City of Albuquerque

RE: TIERRA LA CUEVA, UNIT 1 (C-19/D9)
RECEIVED SEPTEMBER 27, 1991

The drainage report dated September 27, 1991, and sheets 1 - 4) are approved for Preliminary Plat. This approval is based on the following requirements and one recommendation:

GRADING & DRAINAGE PLAN
TIERRA LA CUEVA
UNIT I

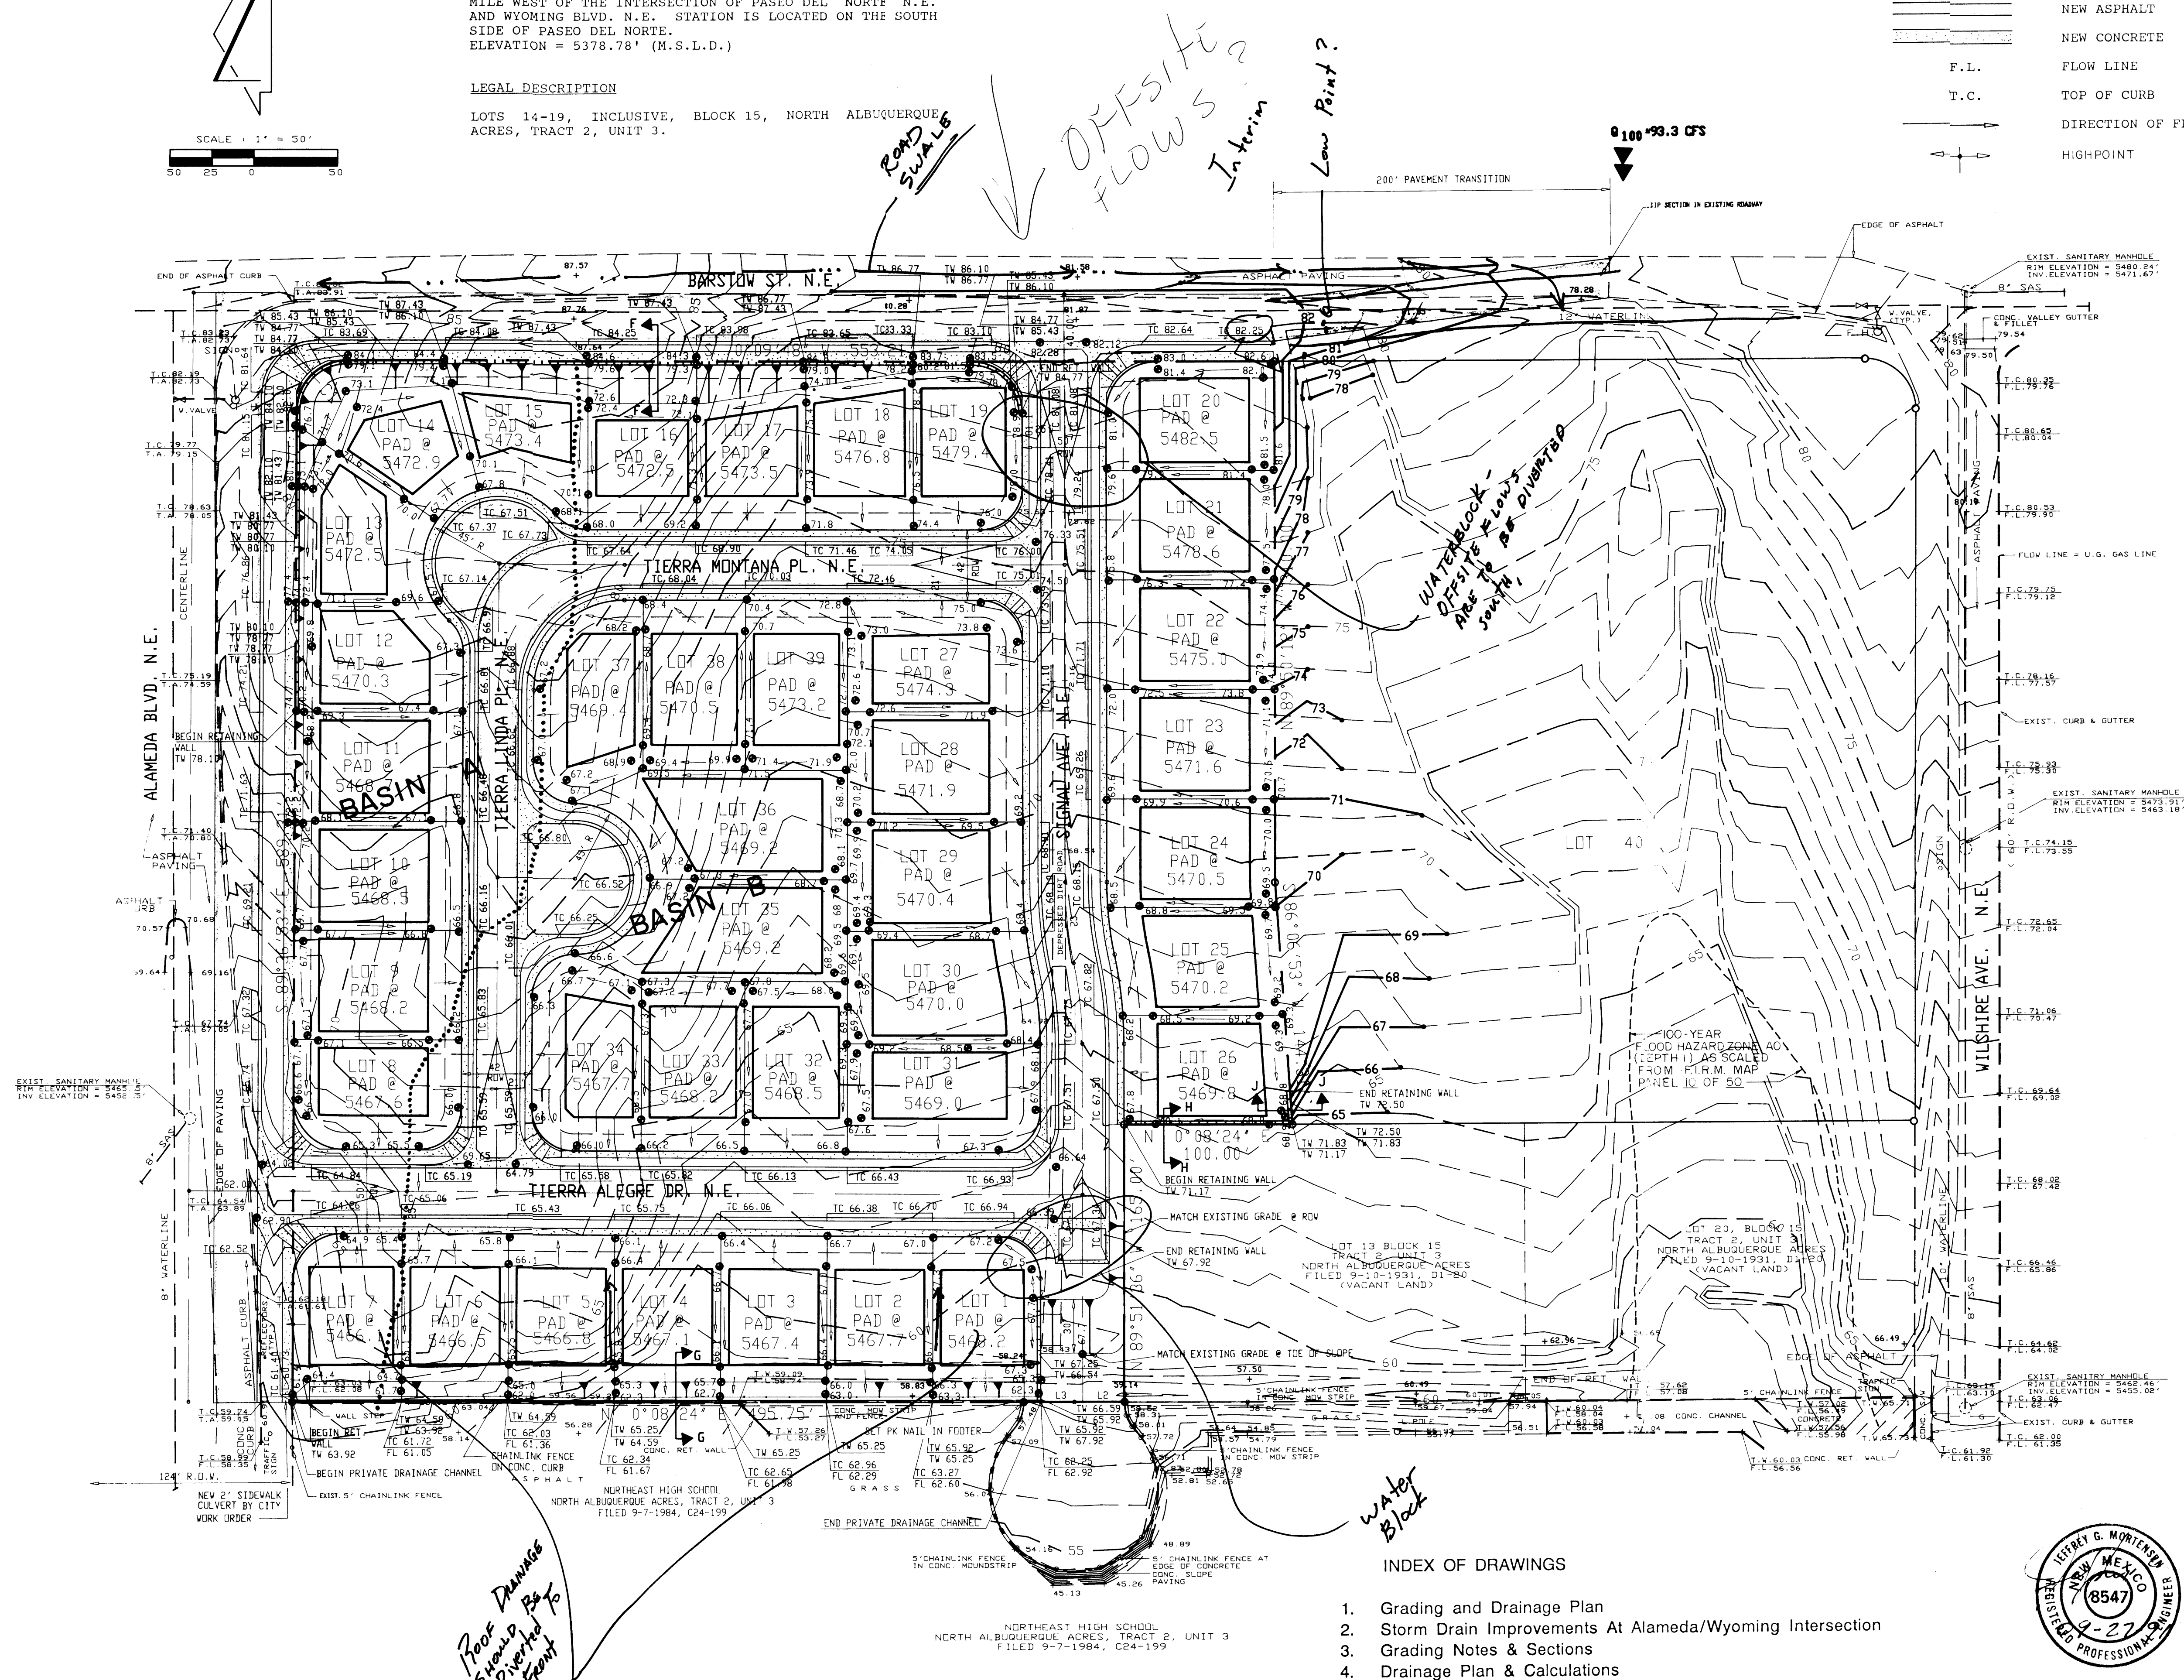
- Include the maintenance responsibility, on the plat, for the private channel across lots 1 - 7.
- Dedicate the floodplain easement on Lot 40 to the City of Albuquerque.
- Forward a copy of the grading plan to Mr. Cloud, and identify the proposed retaining wall height(s) for Lots 1 - 7.
- Recommend that your client provide this office with a certified as-built grading plan upon completion of this project.
- The downstream capacities analysis for Wilshire Boulevard will be deferred to the development of Unit 2.
